Application Ref.: F/4/20/OUT

Proposal: Outline planning application (with all matters reserved except for access) for the development of up to 1,500 dwellings (Use Class C3), 60-bed care home (Use Class C2), up to 9,000 sqm of employment floorspace (Use Classes B1), local centre of up to 2,350 sqm including up to 900 sqm retail/ commercial (Use Classes A1-A5) and 1,450 sqm community/ leisure floorspace (Use Classes D1-D2), land for a two-form entry primary school (Use Class D1), public open space, allotments, new sports pitches and associated facilities, drainage, parking and associated access, infrastructure, landscape, ancillary and site preparation works, including demolition of existing buildings and part removal of existing runway hardstanding.

Location: Land at Ford Airfield Ford

I refer to the above planning application and the recent consultation on the Waste Infrastructure Statement.

Figure 33: Outline Planning Application Parameter Plans - presented in detail on the following pages

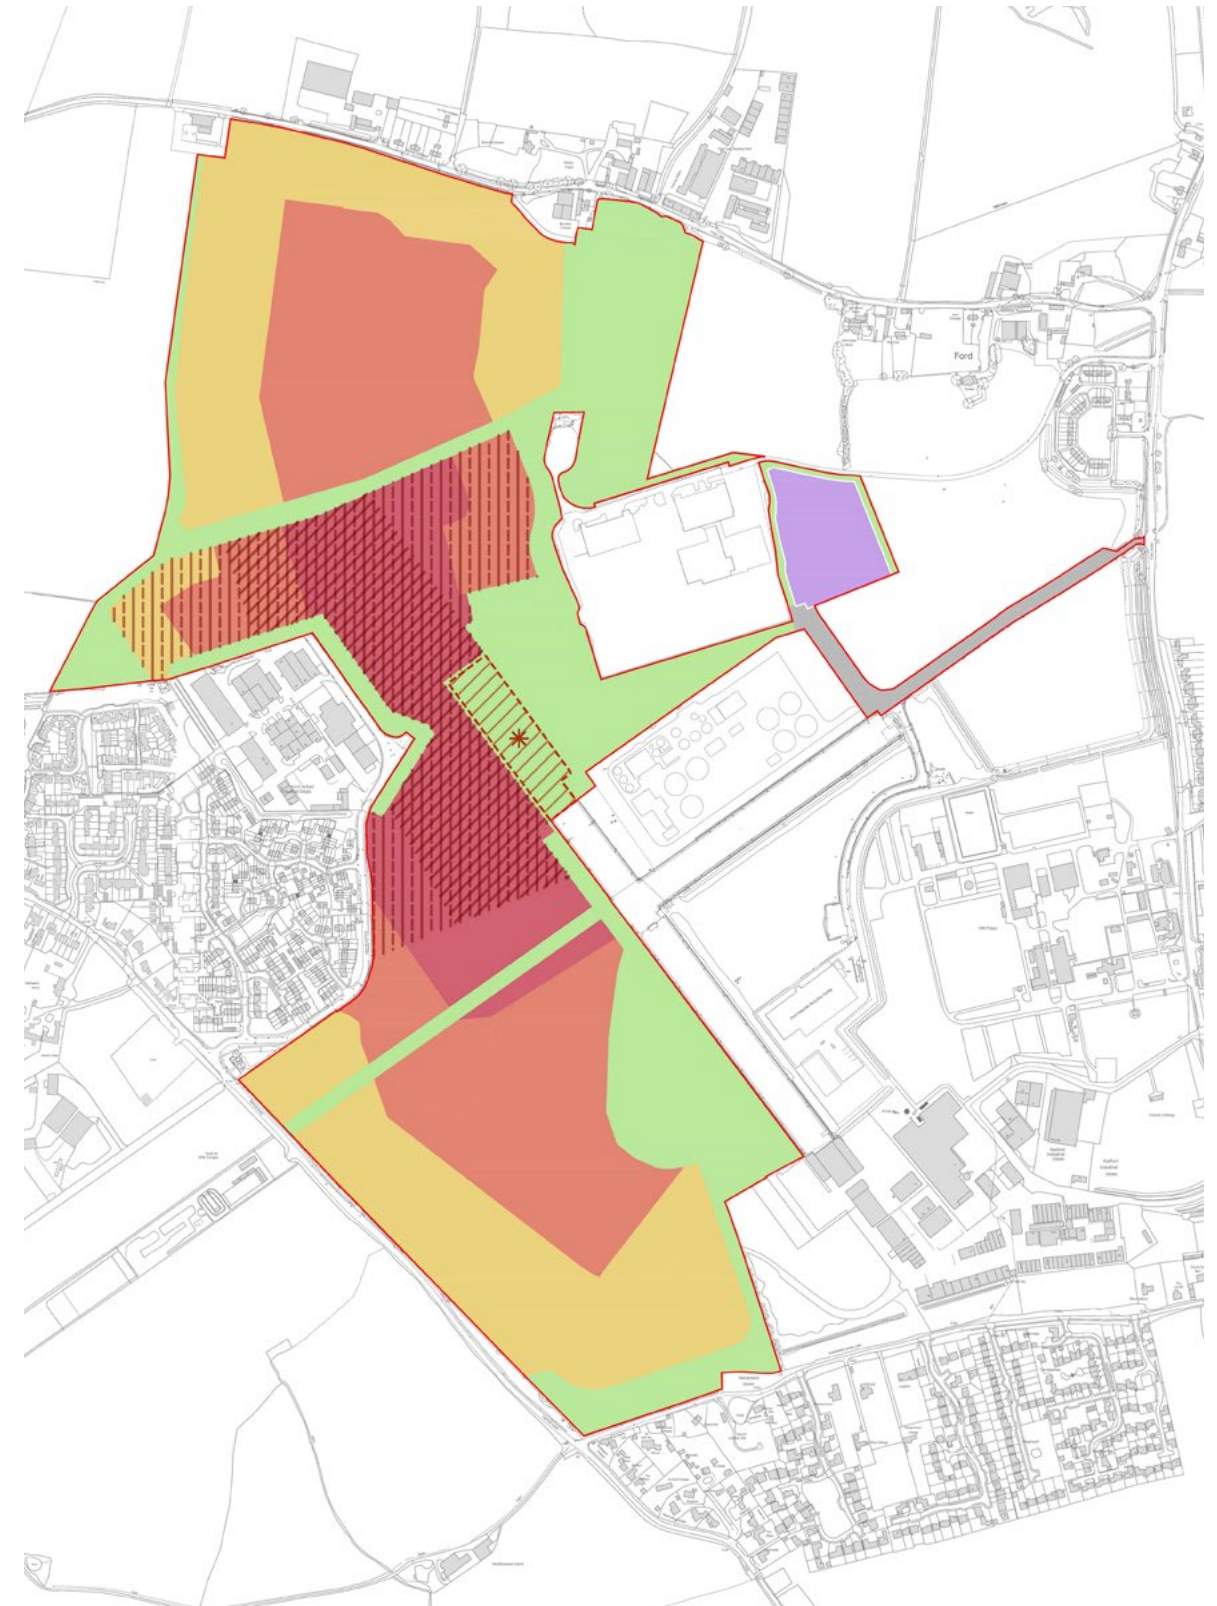
This leaves a problem for both the masterplan and the parameters plans, as they propose housing in locations which may not be acceptable once the detailed designs have been drawn up.

Notwithstanding the land use and density parameter plan (RG-M-123K), a detailed noise mitigation scheme to ensure that noise sensitive properties are protected and current and future waste activities in the area are not prejudiced shall be submitted for the written approval of the LPA. No properties shall be occupied in relation to any application until the noise mitigation scheme has been approved and implemented in full. The noise mitigation scheme shall provide details of the different noise sources in the area and the proposed mitigation relevant to those sources. The mitigation measures to be considered by the mitigation scheme shall include but shall not be limited to those referred to in Section 4 of the Waste Infrastructure Statement, namely:

Figure 3: Potential noise sensitive areas

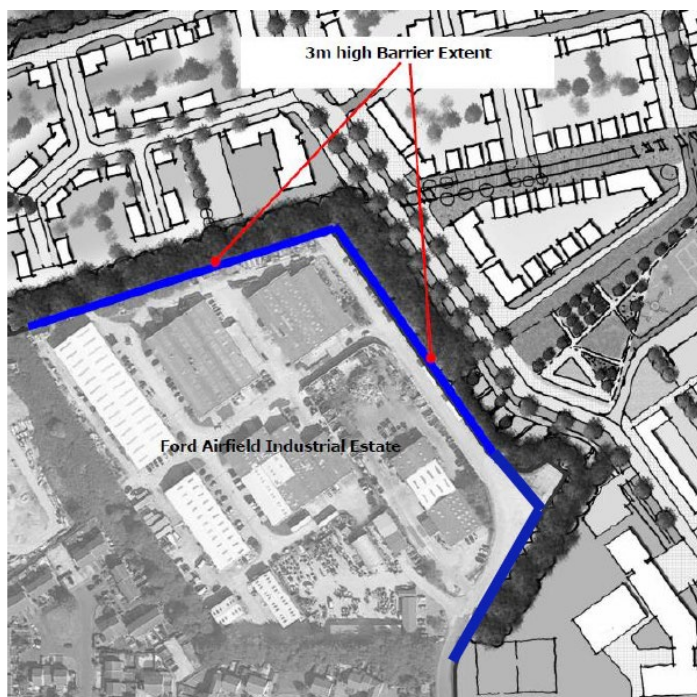
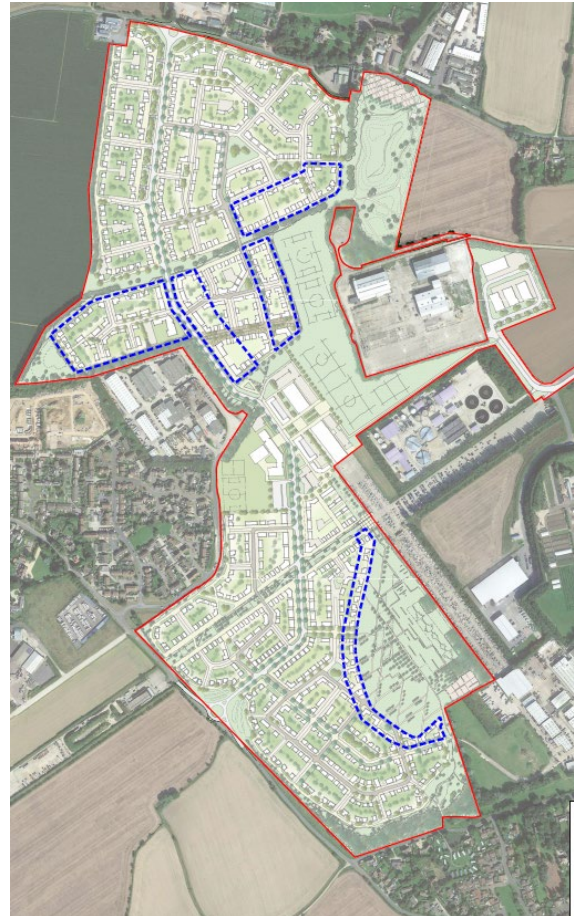
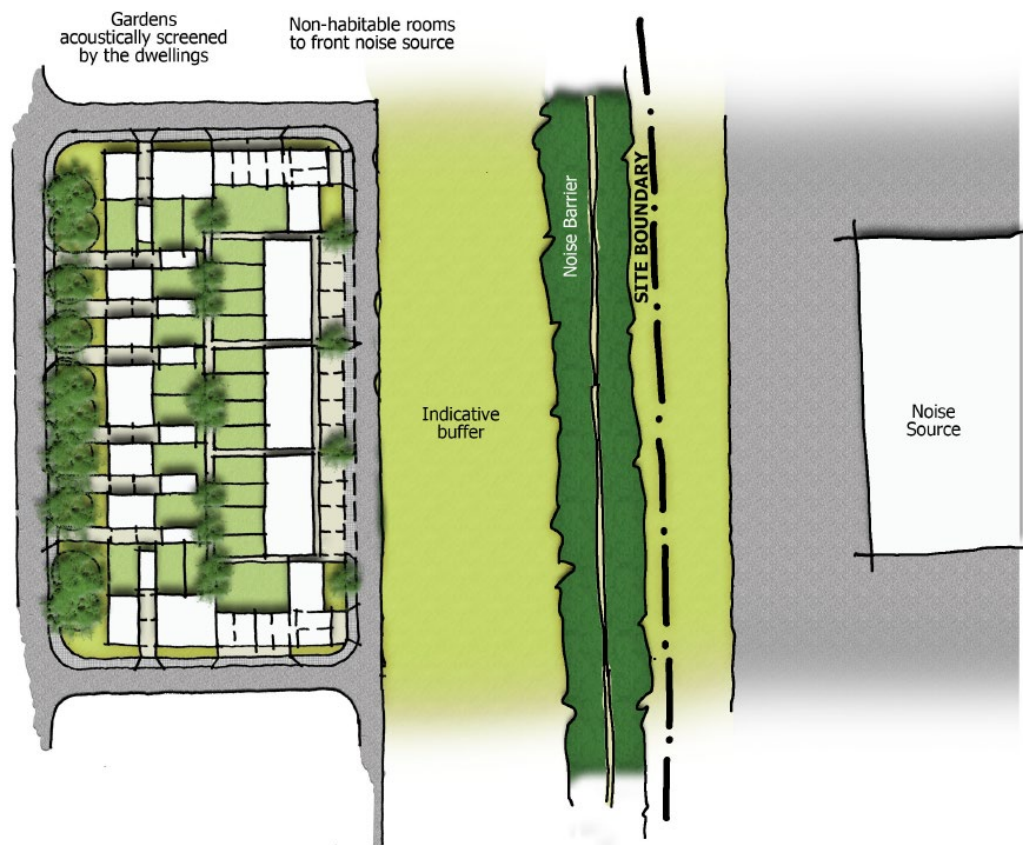
Nevertheless, the Waste Infrastructure Statement finally appears to acknowledge that mitigation is required to ensure that the operation of existing and future waste activities in the area around the site are protected. However, the Waste Infrastructure Statement and the planning application both stop short of detailing the precise nature of mitigation required, leaving that to the detail of a reserved matters/conditional submission at a later date.

- *Appropriate buffer zones between noise sources and noise sensitive properties (e.g. residential, care home)*
- *Acoustic barriers in the form of acoustic fences and landscaped mounds*
- *Orientation of dwellings and gardens so that no habitable rooms are directly facing noise source*
